From: [Kelly Bacon \(CD\)](#)
To: [Mau, Russell E \(DOH\)](#)
Cc: [Holly Erdman](#); [Smits, Brenda M \(DOH\)](#)
Subject: RE: CU-22-00003 Brethren Frontier School - Notice of SEPA action and Public Hearing
Date: Thursday, November 3, 2022 11:48:59 AM
Attachments: [CU-22-00003 Brethren Frontier School - Comments DOH-ODW 9-19-22.pdf](#)

Subject: CU-22-00003 Brethren Frontier School - Notice of SEPA action and Public Hearing

□
 Exg.
 Well
 House

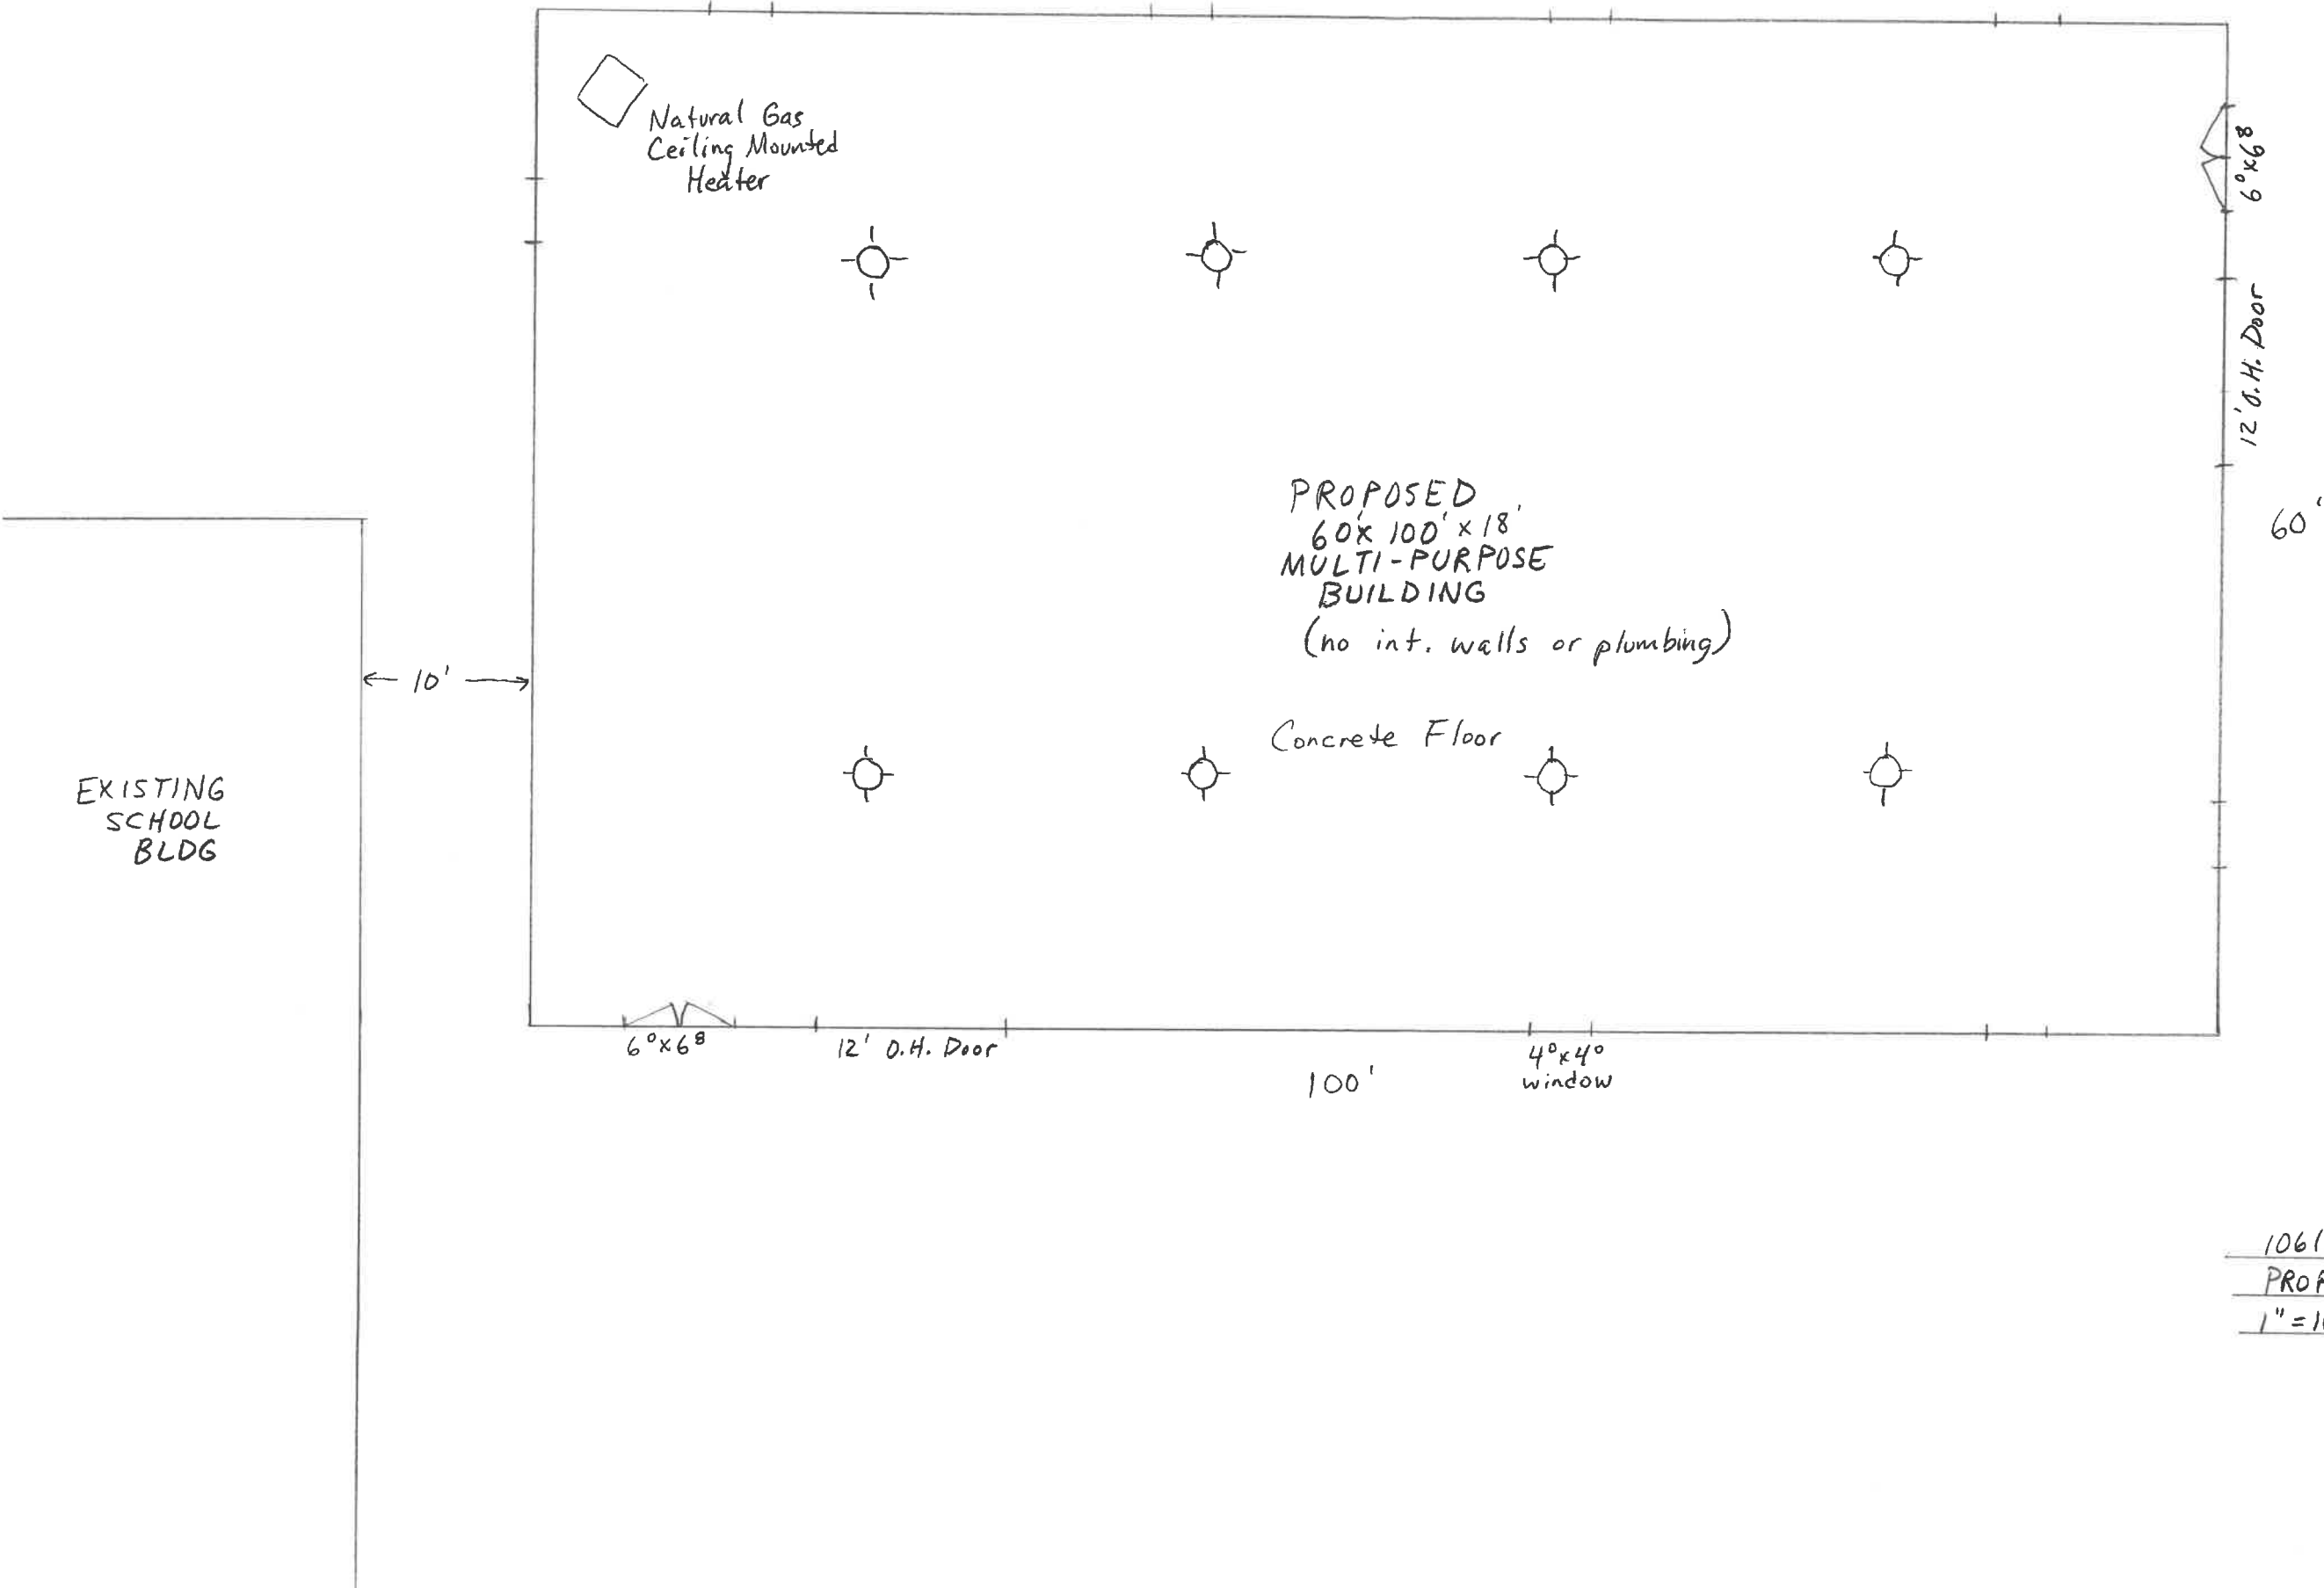
On this application, the applicant has indicated “water” (i.e., drinking water) is already available on-site – what is the source of that water: their own private well, their own well that is part of public water system, or from a public water system?
